**BLOCK 4N CENTRAL PARK – Section 96 Submission  
ARCHITECTURAL DESIGN STATEMENT**

20th January 2016

Block 4N  
External Wall System  
Typical Hotel Slot Facade  
Cladding Type H3

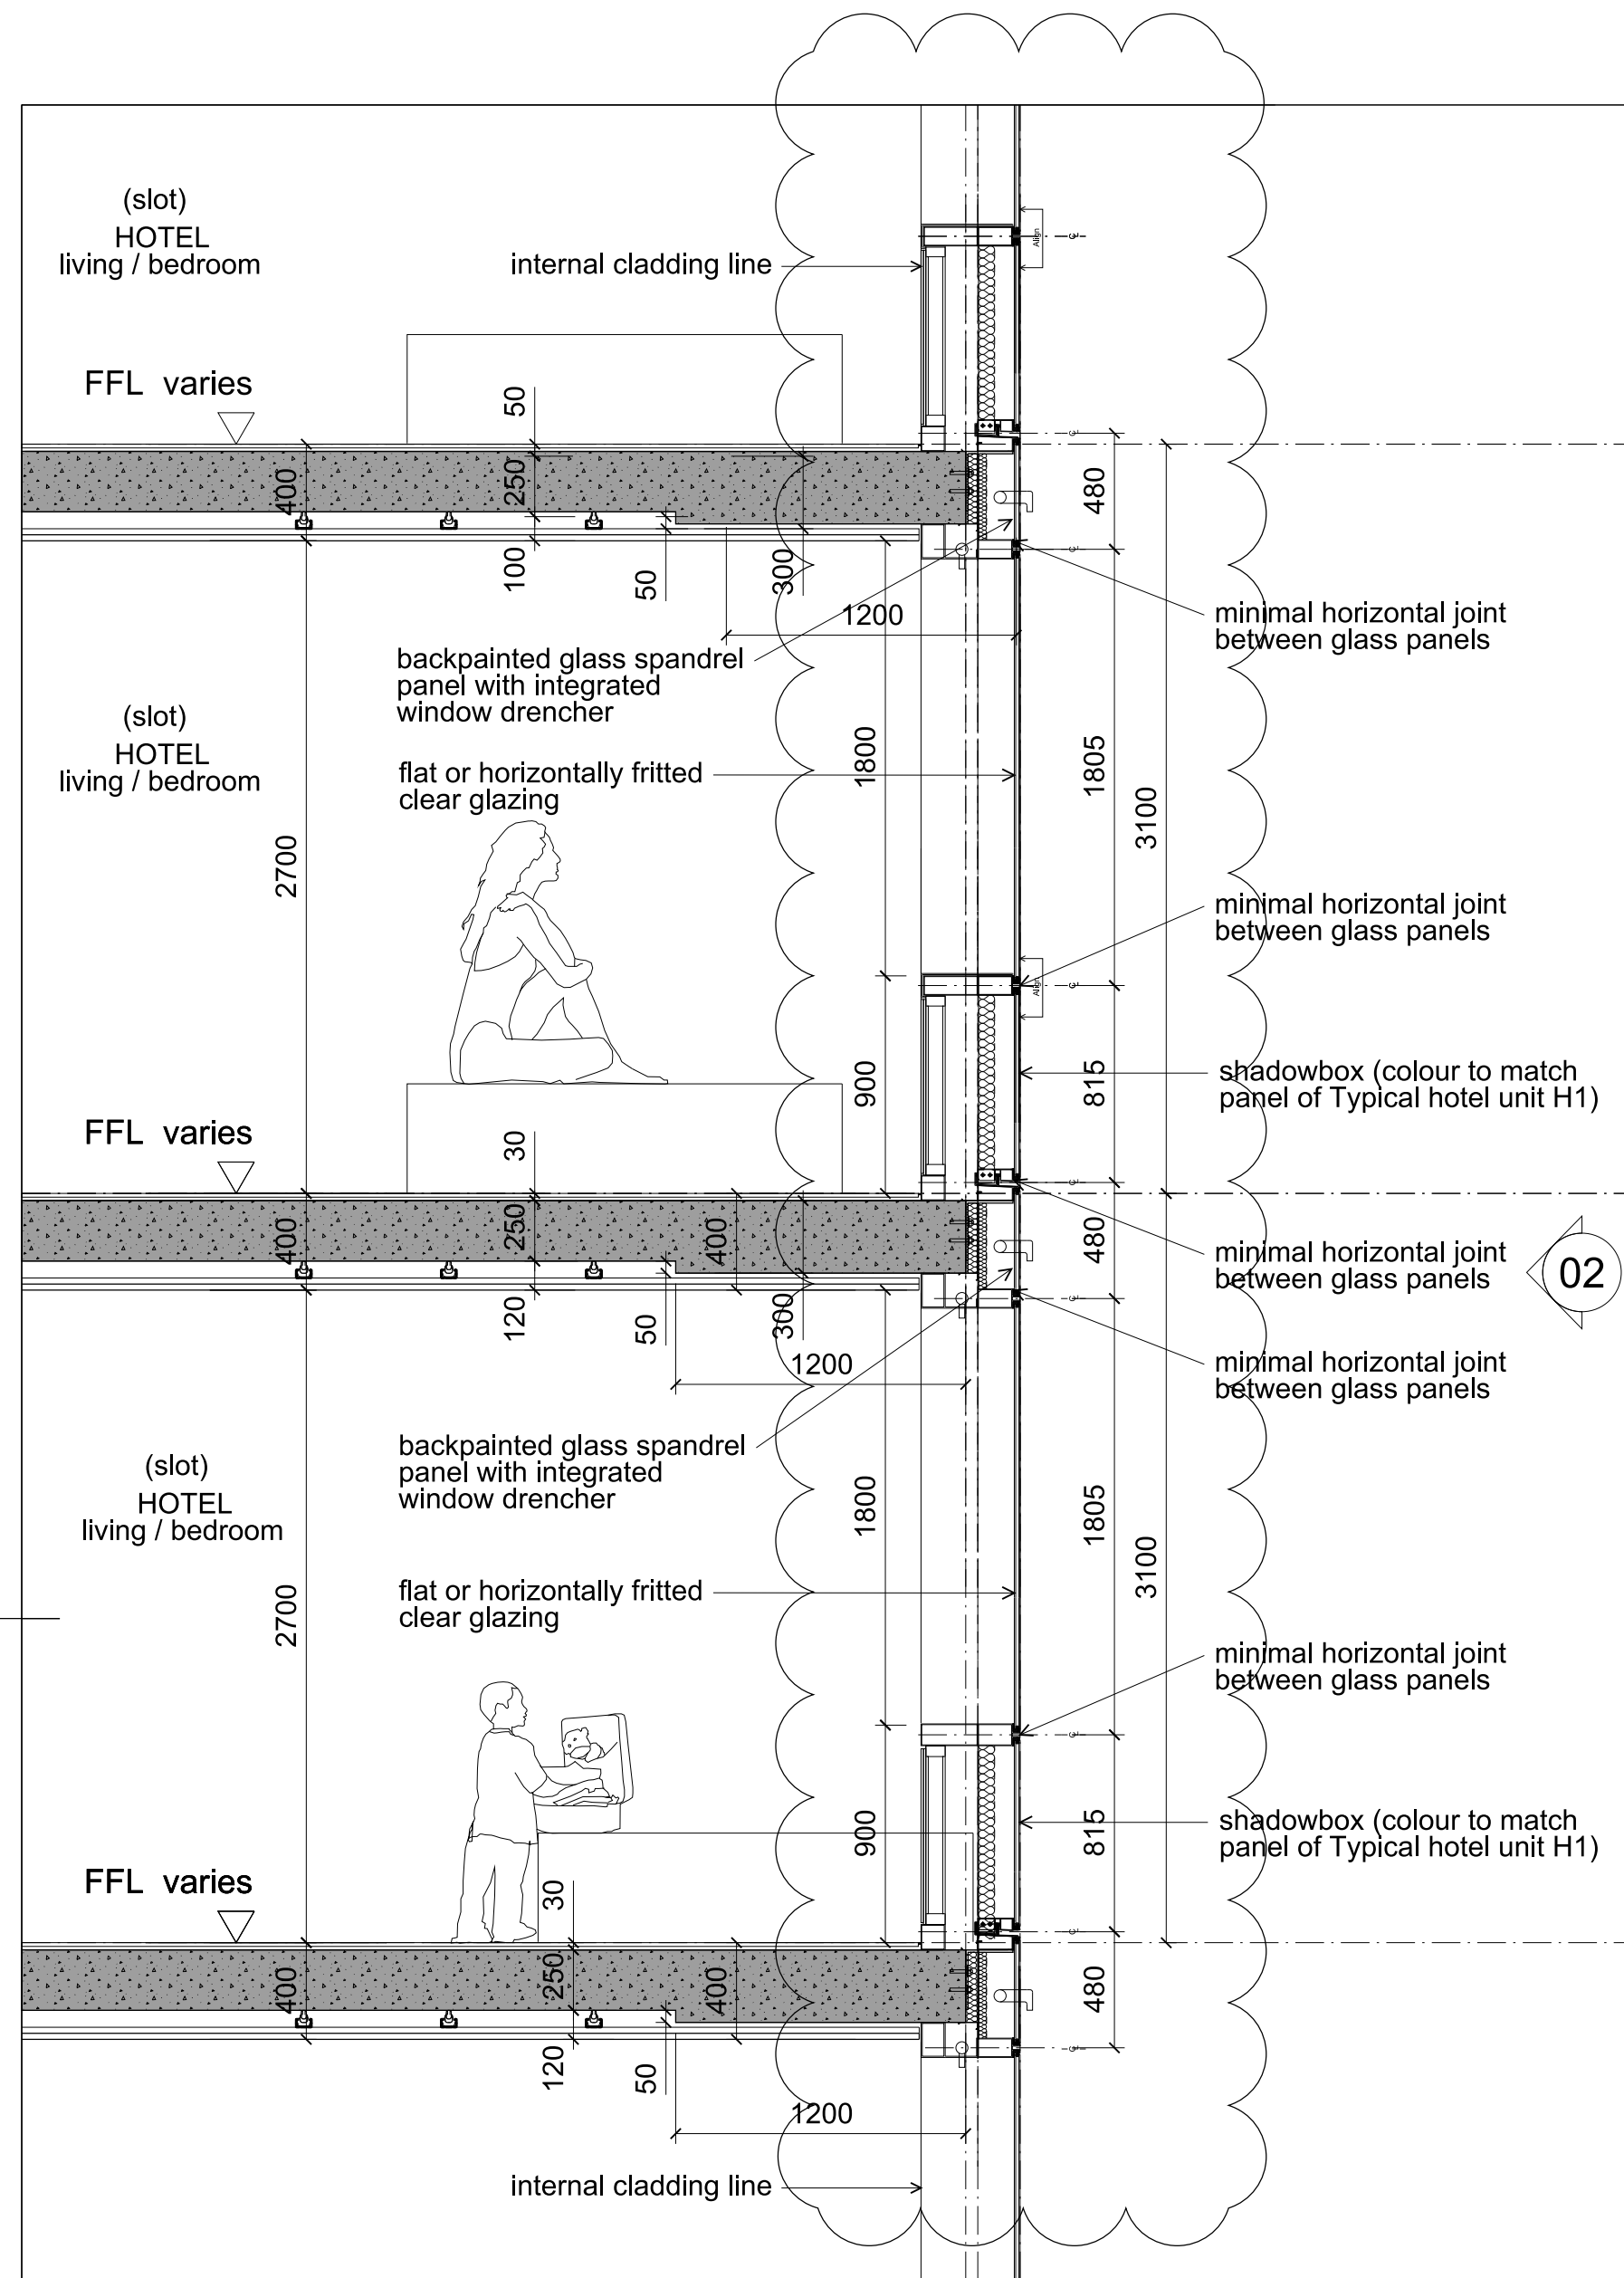
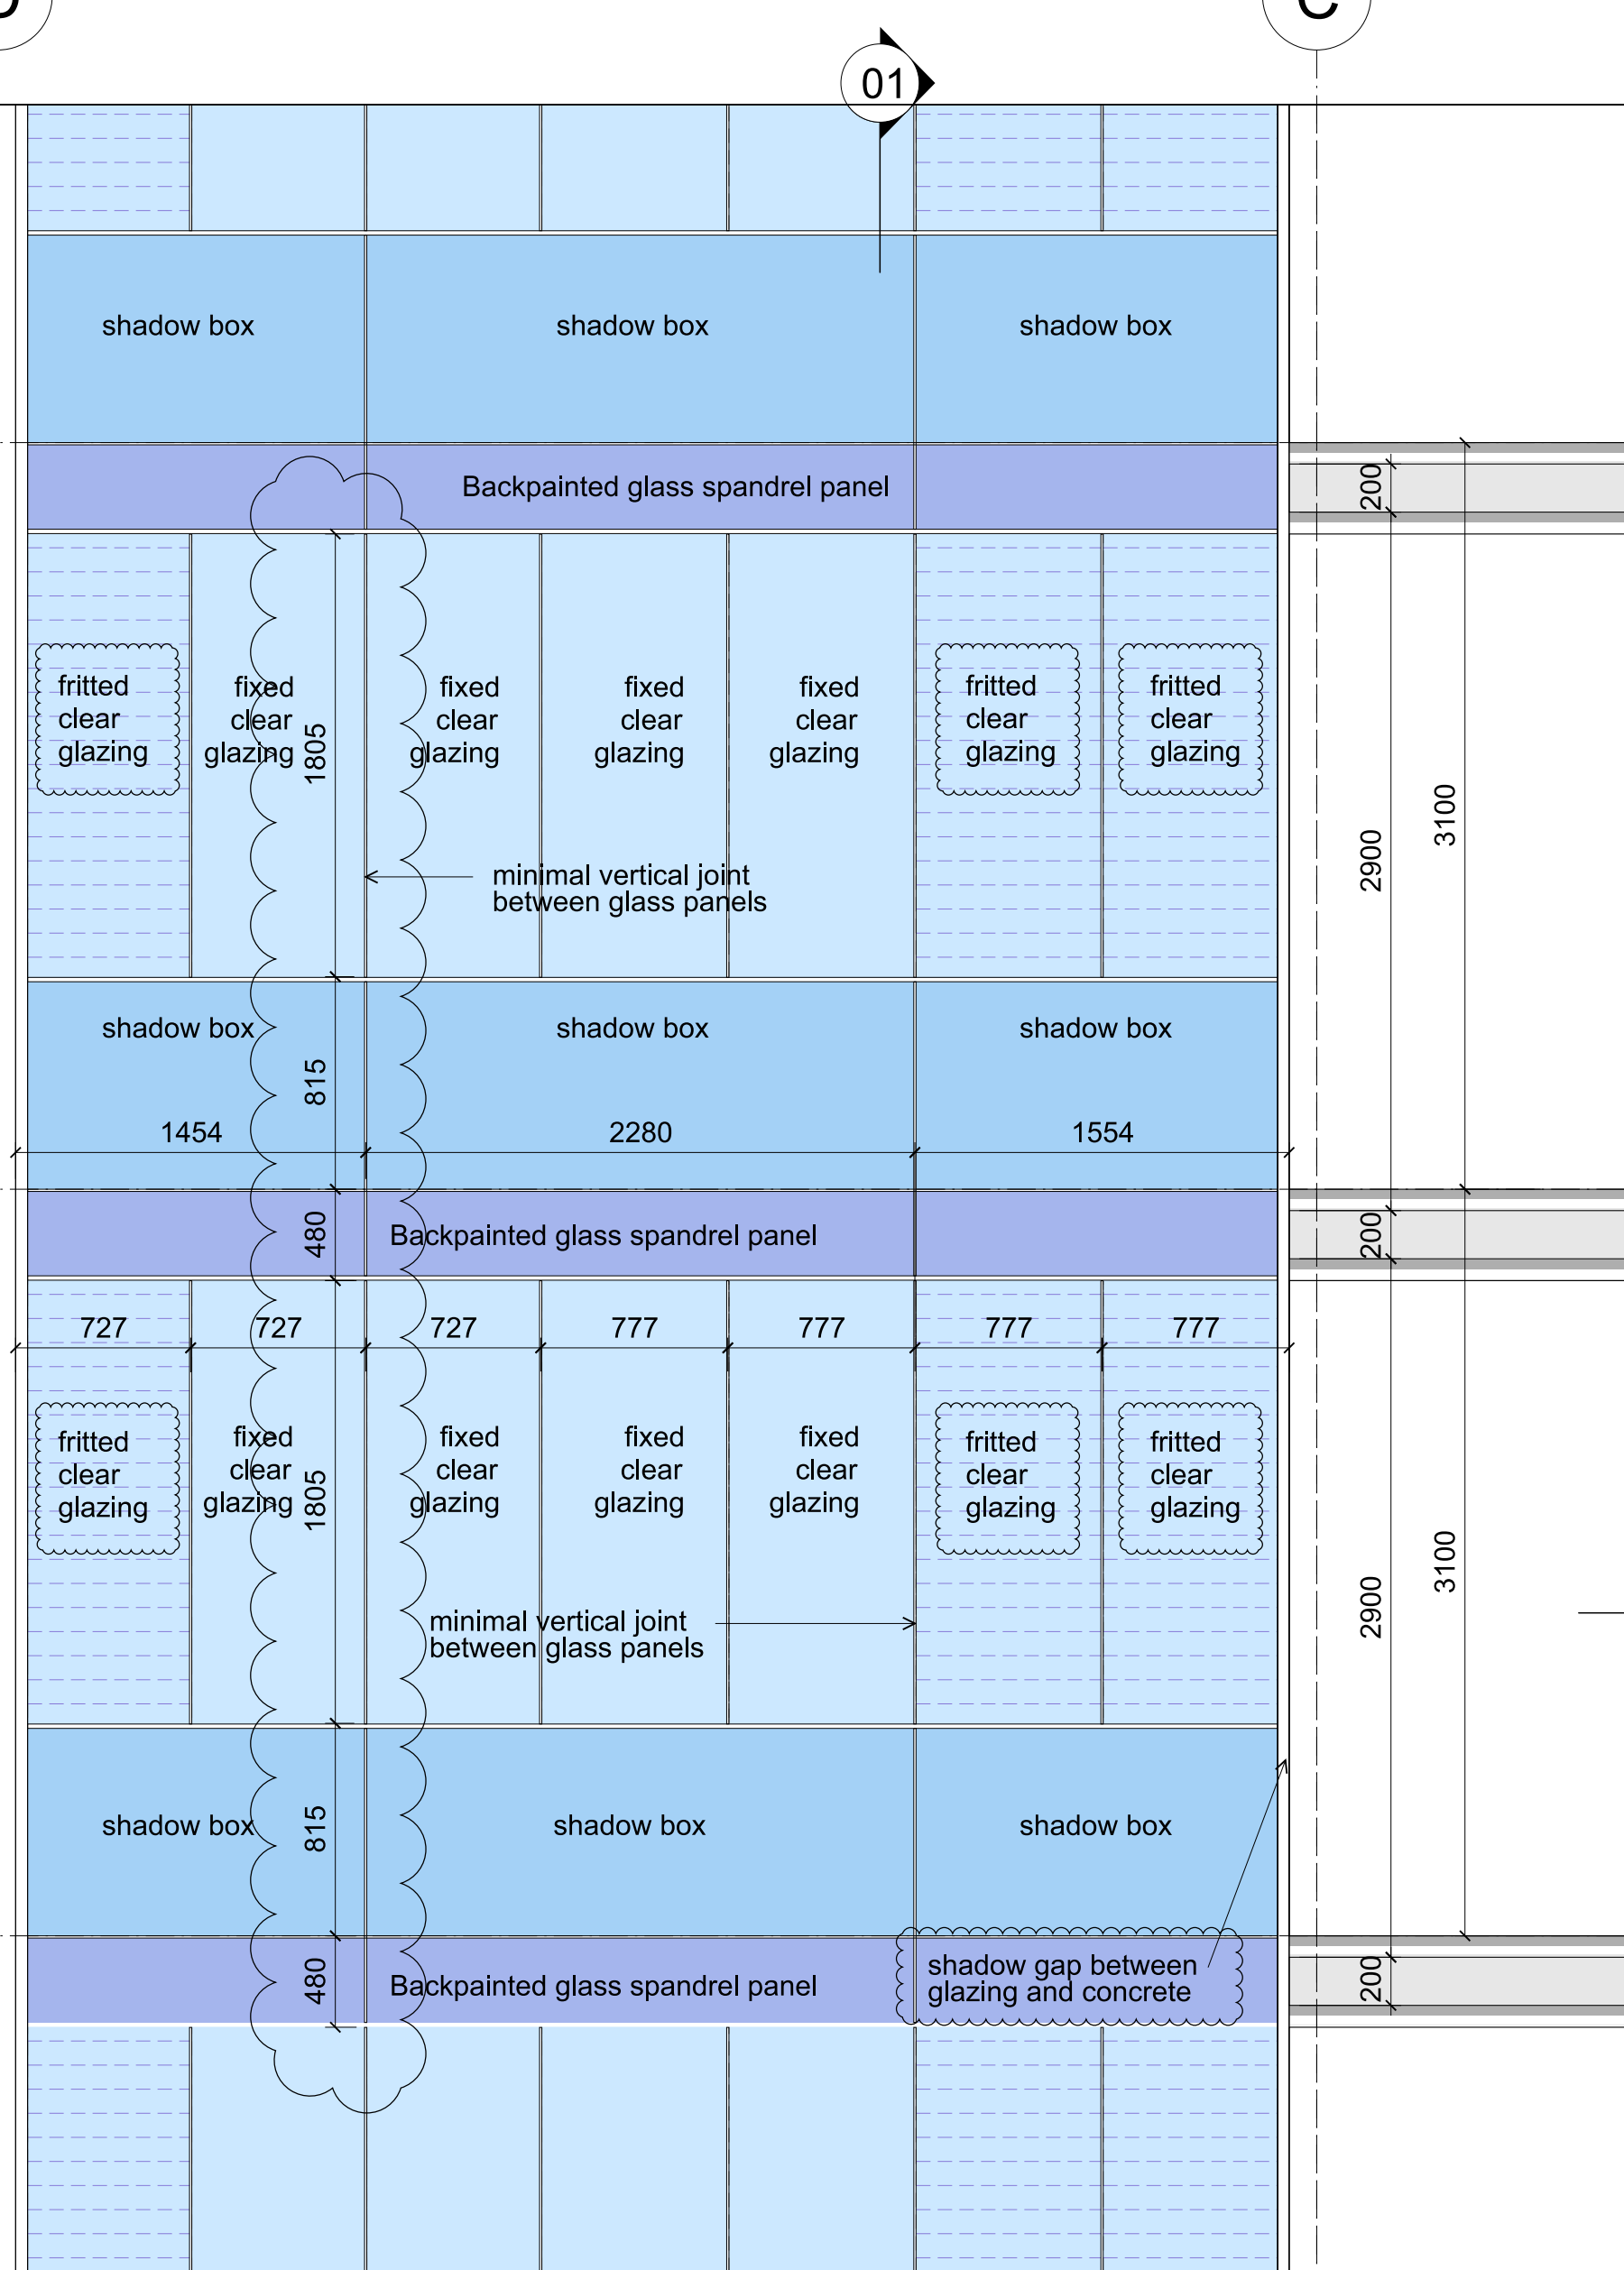
**Podium** At the building 'podium' and recessed 'neck' area level 3 the design of certain areas has been revised in terms of the use and as a consequence we have made revisions to the massing, general arrangement and composition of the facades in order to provide a more suitable layout to cater for the updated Hotel Brief. The internal levels of the first and second floor have been amended to suit the increased conference room facilities and their requirement for larger ceiling voids. This has resulted in a reorganisation of the location of the clear vision glass zones, shadow boxes, spandrel panels, canopies and horizontal metal louvers throughout the height of the podium facades to better suit the updated hotel room functions and layout behind.
